**KIRKLEES METROPOLITAN COUNCIL  
INVESTMENT & REGENERATION SERVICE**

**DELEGATED DECISION TO DETERMINE PLANNING APPLICATIONS**

Reference No:	<b>2024/62/91626/W</b>
Site Address:	23, Highfield Road, Fixby, Huddersfield, HD2 2GF
Description:	Alterations to convert garage to living accommodation
Recommending Officer:	Molly Storer

## HOUSEHOLDER DELEGATED REPORT

PROPOSED GROUND FLOOR

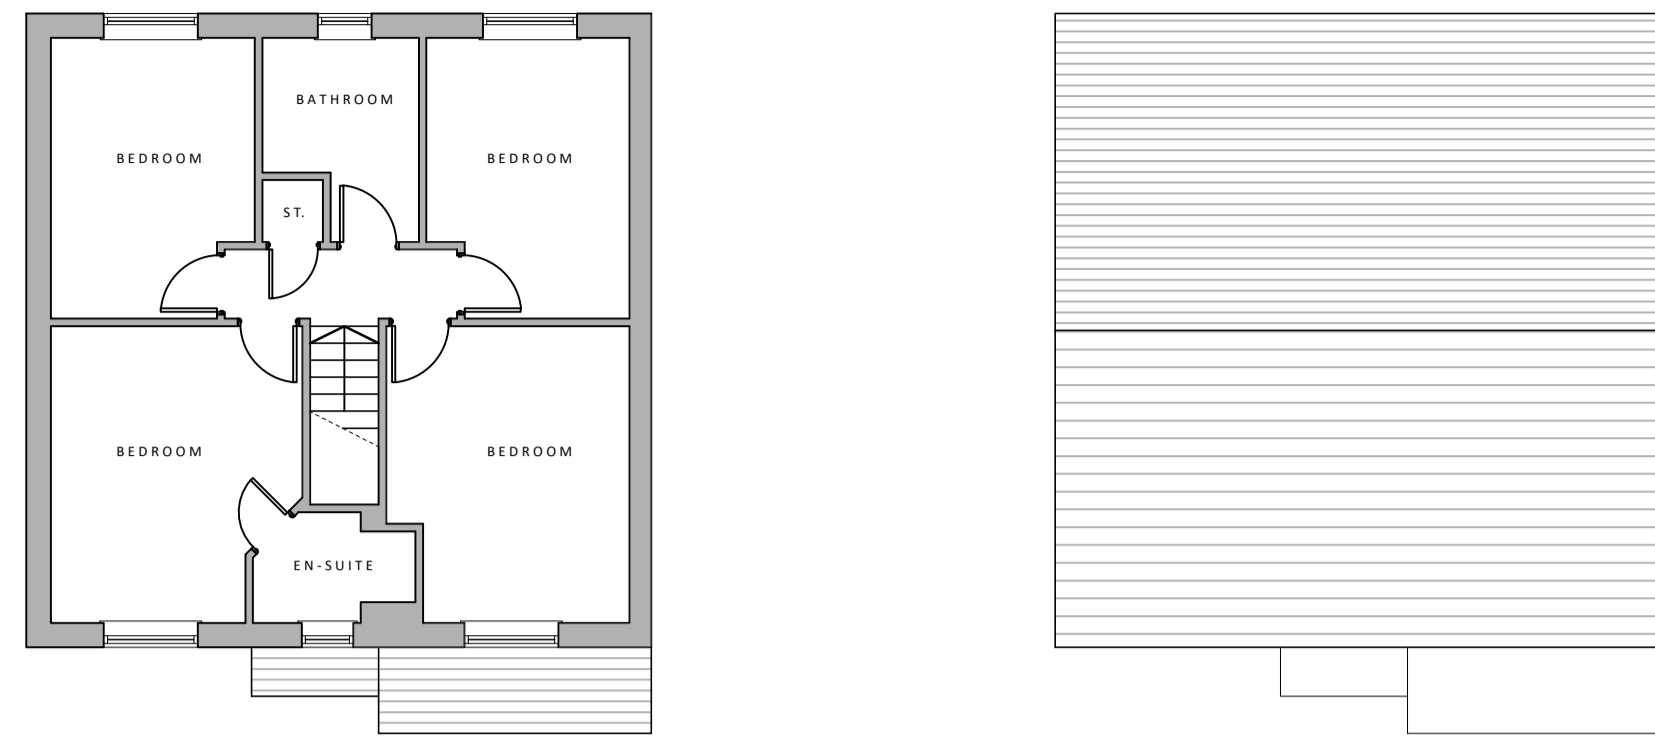
<b>YES / NO</b>	<b>SUMMARY</b>
Negotiations/Amendments during course of application	Yes	Highways requested plans to show how three adequately sized parking spaces will be provided on the site. The agent responded with amended plans to evidence this.
Planning History	Yes	2018/92055 - Erection of 252 dwellings and formation of vehicular access – Section 106 Full Permission.
Consultations required	Yes	K.C. Highways – informally consulted due to the loss of a parking space on site with the removal of the integral garage. See

<p>siting of the property on a turning head, no on street parking can be accounted for.</p> <p>Therefore, it was advised that amended plans should be submitted showing how the site could provide three adequately sized parking spaces.</p> <p>Amended plans were provided that evidenced that three parking spaces could be provided to the front of the existing property with some removal of landscaping.</p>	
Provision for waste storage	<ul style="list-style-type: none"> <li>• KDP 16 of the SPD</li> <li>• Policy LP24 Design (d) (iv)</li> <li>• Chapter 12 of the NPPF</li> </ul>	Not shown on plan however adequate space to provide storage for bins	✓

PROPOSED FRONT ELEVATION

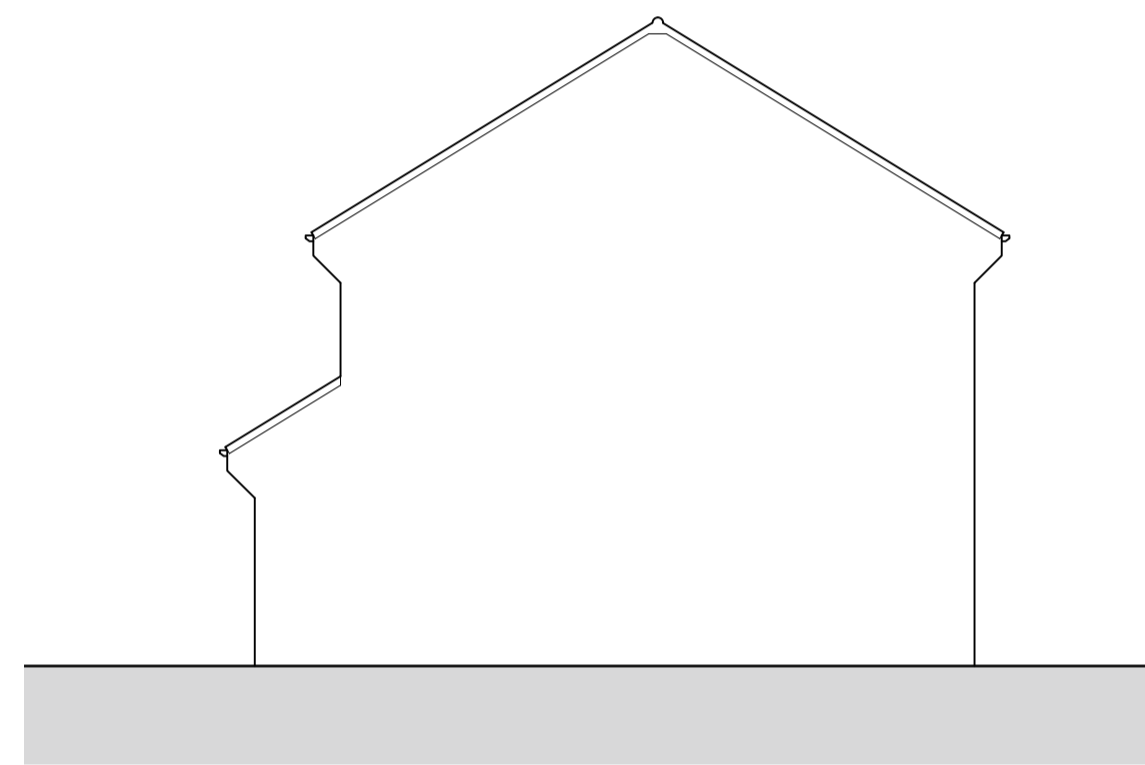
The alterations to convert the garage to living accommodation would not increase the existing structure or footprint of the existing dwelling. The only external alterations would be the removal of the garage door to the front elevation and the installation of one window.

<b>Relevant key design principle (KDP) of the SPD, Policy in the Kirklees Local Plan and the NPPF</b>	<b>Further comments</b>	<b>✓ / X / N/A</b>
Impact on the local character, street scene and original house	<ul style="list-style-type: none"> <li>• KDP1 of the SPD</li> <li>• Policy LP24 Design (a) and (c) of the KLP</li> <li>• Chapter 12 NPPF</li> </ul>	Although the proposal would alter the appearance of the front elevation of the dwelling this is considered to harmonise with the original house due to it utilising matching materials and having a window which align with the ground floor window on the same elevation. It is considered that this appearance would not	✓
